**STATE SIGNIFICANT DEVELOPMENT  
ASSESSMENT REPORT:**

- ***LEES 1 Science Research and Teaching Facility (SSD 7054); and***
- ***F23 Administration Building (SSD 7055), the University of Sydney***

Environmental Assessment Report  
Section 89H of the *Environmental Planning and  
Assessment Act 1979*

November 2016

Original Eastern Avenue interface - typical upper level plan

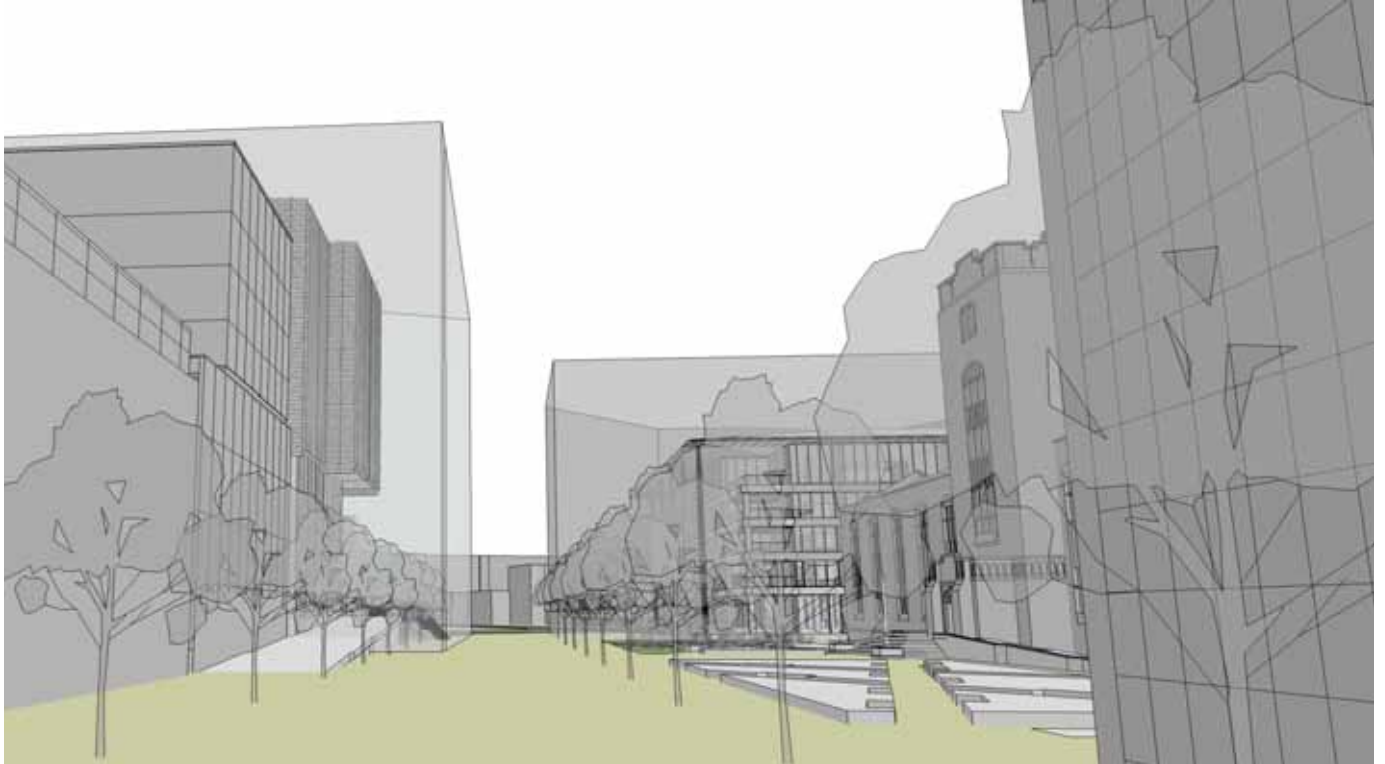
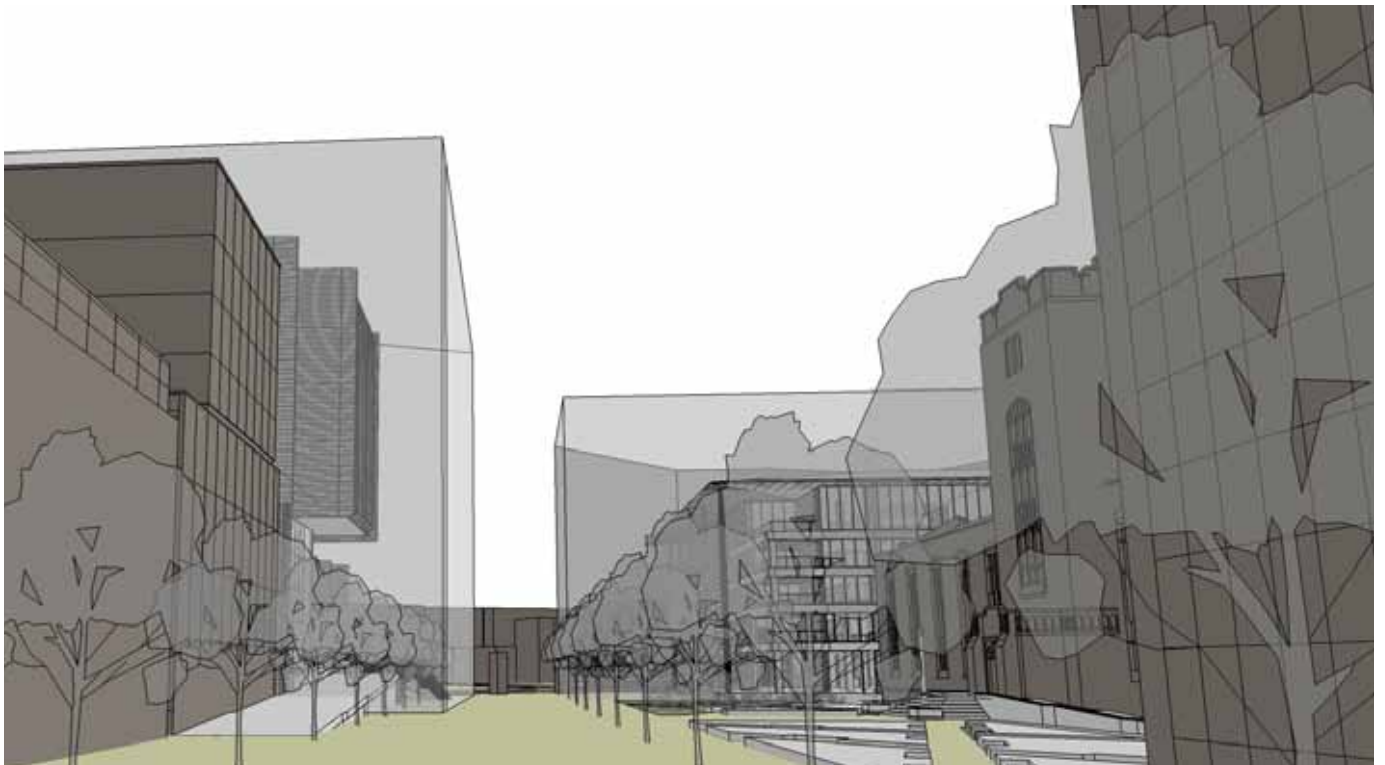
- the proposed floor plate design requirements and resultant encroachment of the upper levels of the LEES 1 building into the Eastern Avenue view corridor, described as a significant view corridor that in accordance with the University's Grounds Conservation Management Plan (GCMP) "*should be retained and if possible enhanced*", is not considered to be an extraordinary circumstance that justifies this, and will weaken the strength of the 'grand vista';

- it is recommended that the upper levels of the Eastern Avenue elevation are redesigned such that the building in its entirety does not protrude beyond the alignment of the adjoining Carslaw building;

Original Eastern Avenue interface - level 3 (bridge interface) plan

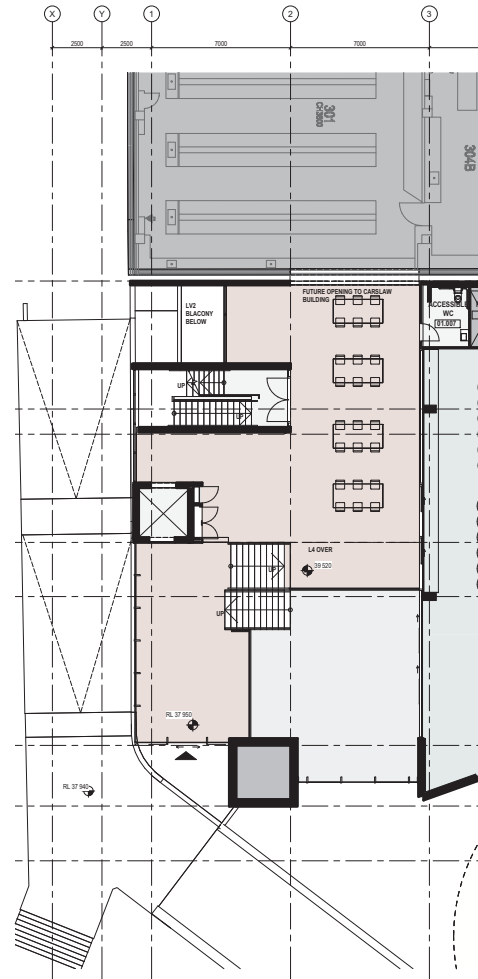
- the proposed building entrance designs are not clear or legible and opportunities exist for alternate design solutions to provide a more generous and visible opening;

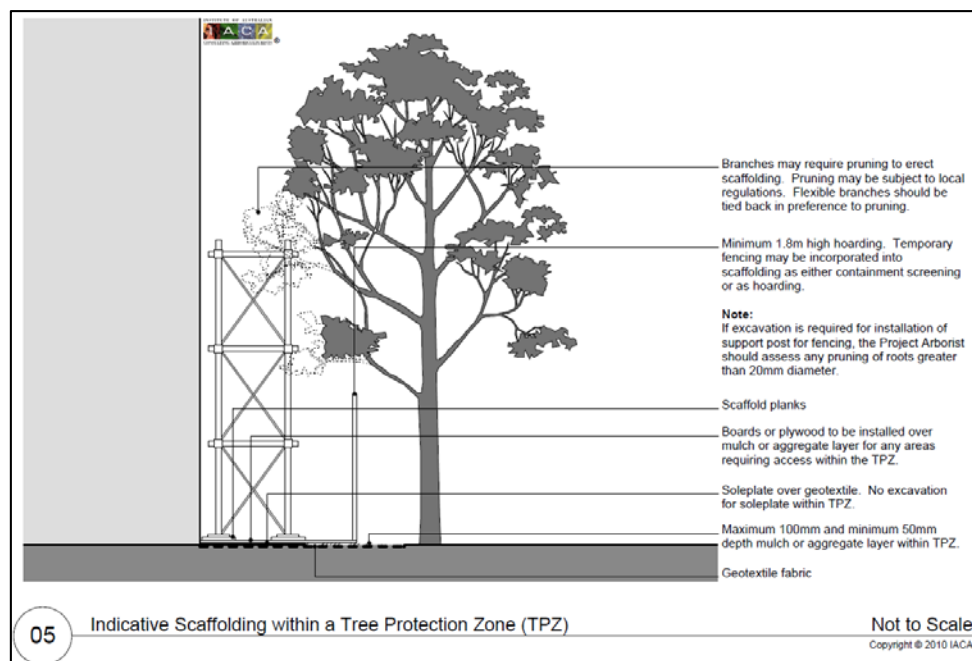
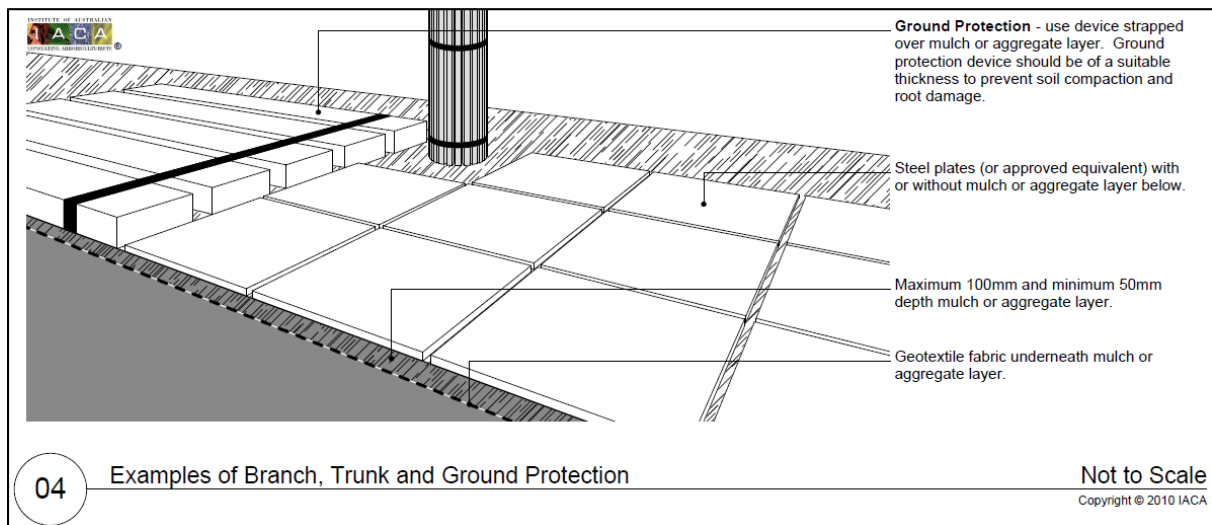
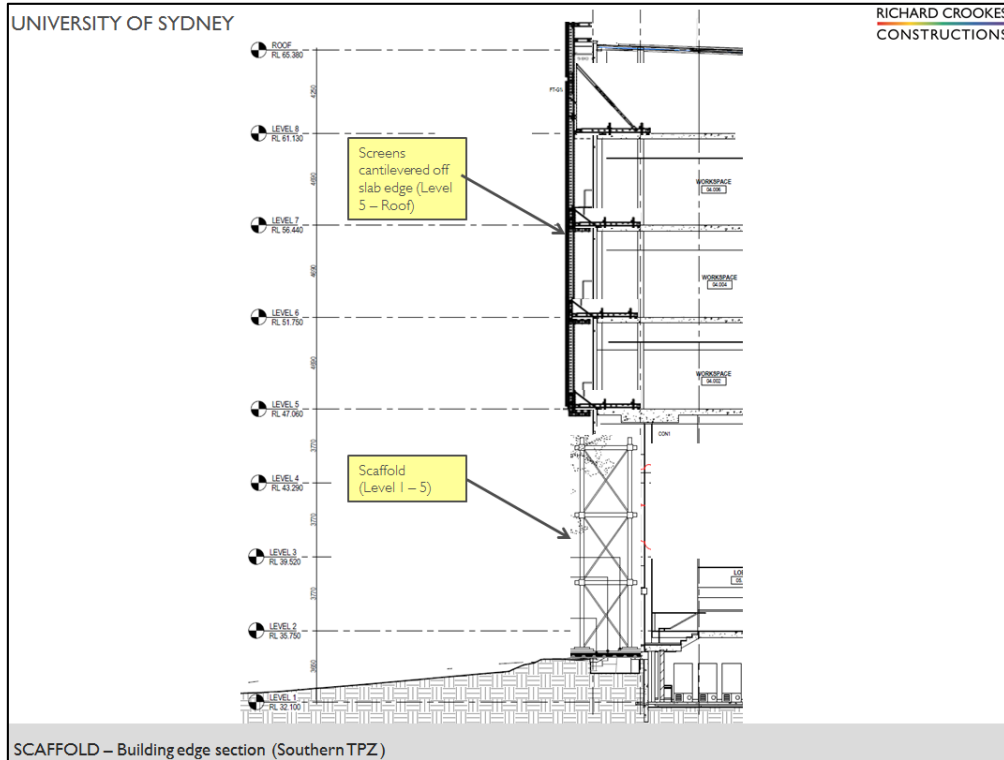
- the amount of pruning to the existing significant Moreton Bay Fig trees anticipated by the applicant's submitted arborist report does not reflect the distance of the trees from the proposed building or allow for scaffolding/hoarding, building clearance and construction access requirements, or allow for future tree canopy growth;

- it is recommended that the building be setback from the trees to allow a minimum two metres from the existing canopy edge;
- Council does not consider the exploratory root investigations undertaken and detailed within the submitted arborist report provide a true representation of possible root impact on the significant Moreton Bay Fig trees and that further investigations be undertaken to determine the exact extent of impact;
